**KIRKLEES METROPOLITAN COUNCIL
INVESTMENT & REGENERATION SERVICE**

DELEGATED DECISION TO DETERMINE PLANNING APPLICATIONS

Reference No:	2023/62/92649/W
Site Address:	Basement Store, 1000-1004, Manchester Road, Linthwaite, Huddersfield, HD7 5QQ
Description:	Change of use of basement floor to 3 studio flats and erection of first floor extension to form 1 studio apartment (within a Conservation Area)
Recommending Officer:	Katie Chew

DECISION - REFUSED

Proposed Basement Floor Plan Scale 1:200

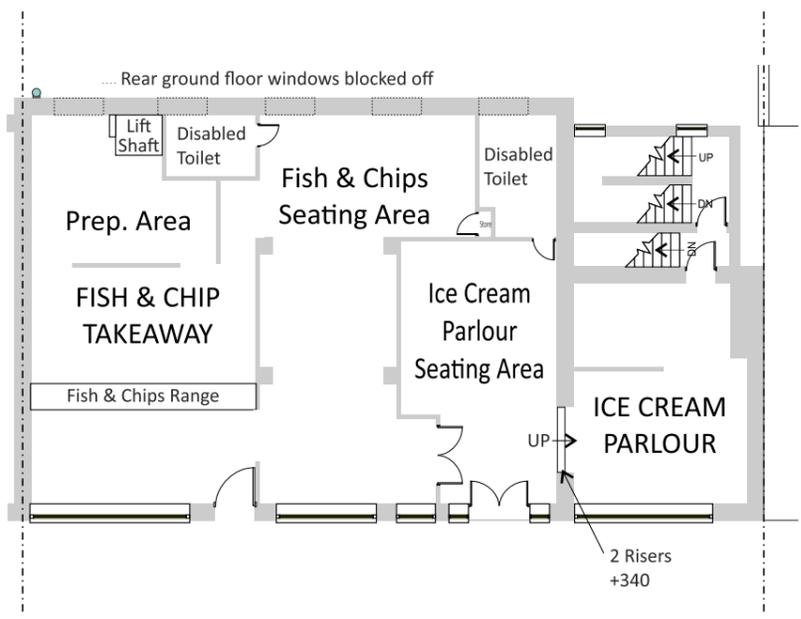
In this instance officers note that the internal floor space for three of the flats would meet the Nationally Described Space Standards for a single storey unit, although it is noted that Flats 2 & 3 could only be occupied by a single person to ensure compliance. On balance, these 3 flats are considered acceptable in terms of the internal floorspace amenity they would provide. However, it is acknowledged that Flat 4 would not meet the requirements of a 1-person unit set out in the NDSS, and officers are very much concerned that this would result in a poor standard of amenity for the future residents of this unit due to the limited internal floorspace and therefore cannot support this proposal on this basis.

The apartments would provide outlook and natural light from windows within either the front or rear elevations. Whilst Flat 4 does benefit from 2 windows within the front elevation and would be acceptable, Flats 1, 2 and 3 have a severely restricted outlook and natural light from their single window facing north. The depth of the studios would result in limited light penetrating these units. Furthermore, the single window and door would have an outlook to a shared parking area as the proposed windows would look out towards the car parking area as well as not receiving any direct sunlight given their northern orientation. Furthermore, the proposed bedroom areas are located to the rear of the units and therefore would have an even further limited access to natural light from the proposed window, it is therefore concluded that Flats 1, 2 and 3 would not provide an acceptable residential amenity for future occupiers of the units. In addition to this, the commercial bin storage area is shown close to the doorway of flat 1 which cause also cause noise and disturbance to residents of this unit.

site. A higher level of sound insulation would also need to be considered where a residential property and commercial property share a party wall/floor/ceiling. This information was requested in August 2022 under previously refused application 2022/90728 and was outlined within the Officers Report. Unfortunately, this information has again not been provided within the application submission. Without this information and taking into account the close proximity of a number of extract ventilation systems to apartments 1-3, the commercial bin storage area adjacent to apartment 1 and Manchester Road even if a satisfactory noise and odour impact assessment was submitted, this is unlikely to result in a good standard of amenity for future residents. Overcoming these matters satisfactorily would not alter the substandard size and ceiling height of unit 4 or the dark and oppressive living conditions for residents of units 1-3.

Proposed Front Elevation Scale 1:100

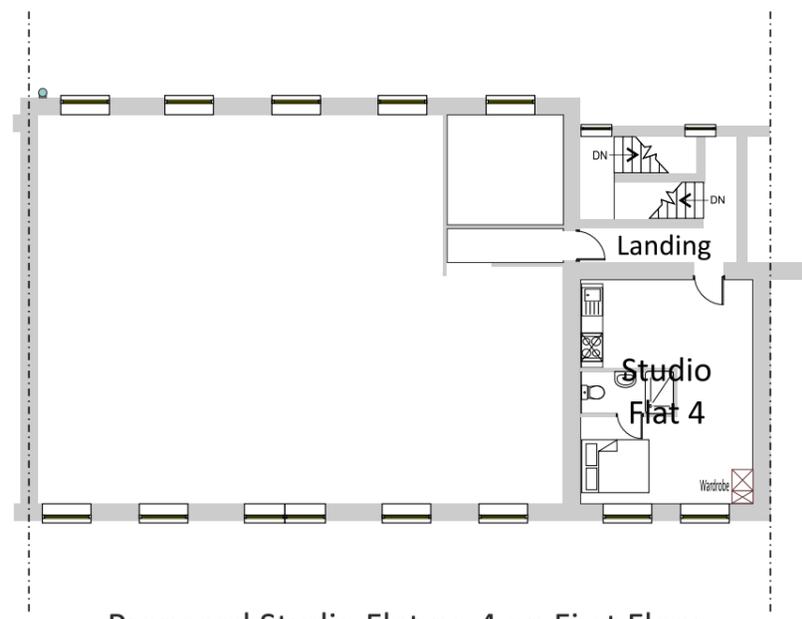
Regarding visual amenity and the impact on the Conservation Area, the majority of the works are to consist of internal alterations and as such would have minimal, if any impact on the significance of the Conservation Area. However, external alterations are also proposed in the form of an extension to the part of the existing building, which would see an increase in the roof height of around 2.4m. The extension is to have a pitched roof constructed from grey concrete roof tiles and would be stepped down from the ridge of the existing dwelling. Changes also include the installation of 4 new doors and 3 new windows within the rear elevation, alongside the installation of 2 new windows within the front elevation of the host property. These are to be similar in size and design to windows already existing on these elevations, include stone lintels and are to be constructed from white UPVC to match the existing windows and doors.

Whilst the proposed extension would be built flush with the principal and rear elevation of the existing building and would not provide a separation distance to no. 998A Manchester Road, this layout is deemed to be most appropriate in this location given its linear appearance which is reflective of the existing row of terrace properties along this stretch of road. The proposed extension does seek to provide a pitched roof design which benefits from a lower ridge height when compared to the host dwelling, this does help to ensure the proposals appear subservient in scale. Overall officers are satisfied with the design and materials proposed, with detailed conditions, as noted within the previously refused application (2022/90728), Conservation & Design officers would wish

to see the existing clay ridge detailing and matching roof slates be provided on the roof of the proposed extension. That being said this could be controlled via a condition should planning permission be granted.

Proposed Studio Flat no.4 on First Floor
First Floor Plan Scale 1:100

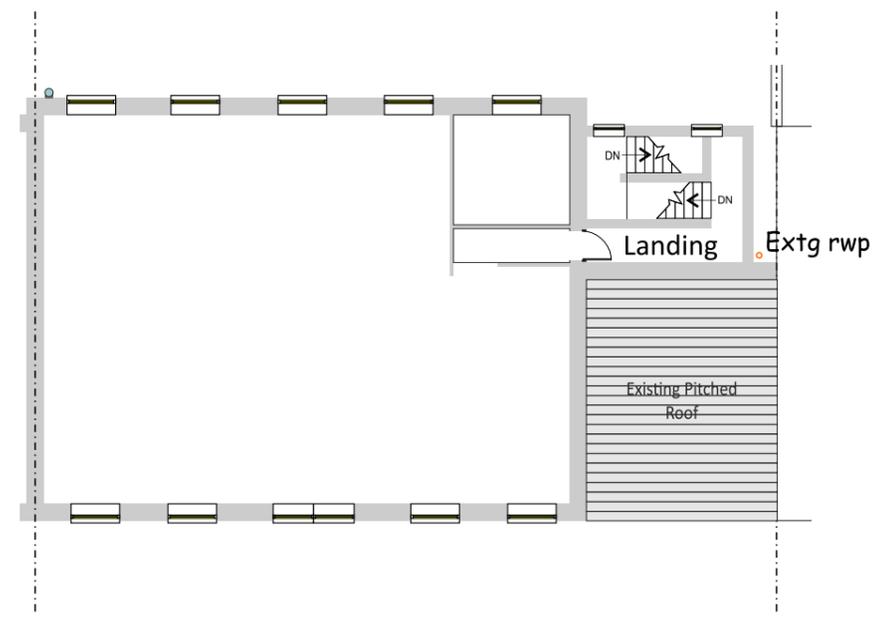
For flat 4 this is further compounded by the limited floor to ceiling heights provided within Flat 4. The technical standards require a head height of 2.3m for at least 75% of the gross internal area, Flat 4 would provide a head height of 2.2m throughout the whole of the unit.

Proposed Site Plan Scale 1:500

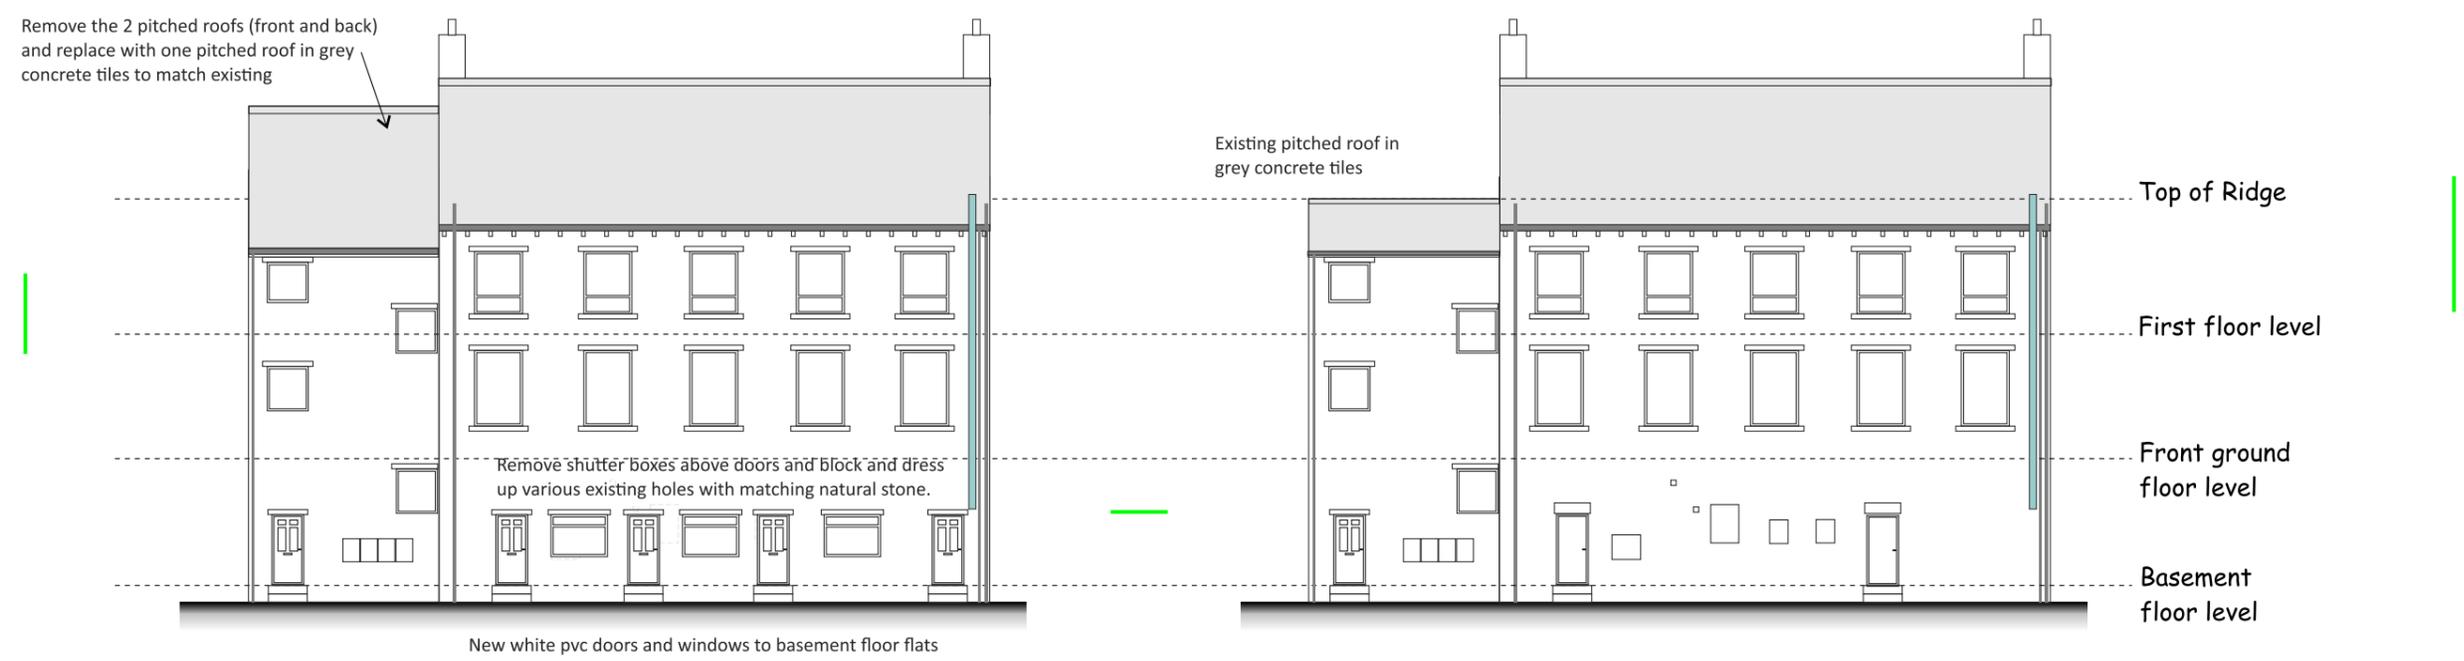
The proposals seek to convert the part of the existing commercial premises to form 4 no. 1 bed flats with the retention of 2 existing flats. Access is to be taken via Manchester Road, with vehicular parking provision of 8 spaces provided to the rear off Coldwell Street. The utilisation of the existing access and parking spaces provided is considered to be acceptable, this view is supported by the Council's Highways team who were consulted on the previously refused scheme at this site, under application reference 2022/90728.

Whilst no details have been provided with regards to the storage and aid of the collection of waste, should planning permission be granted a condition is recommended requesting this information be provided.
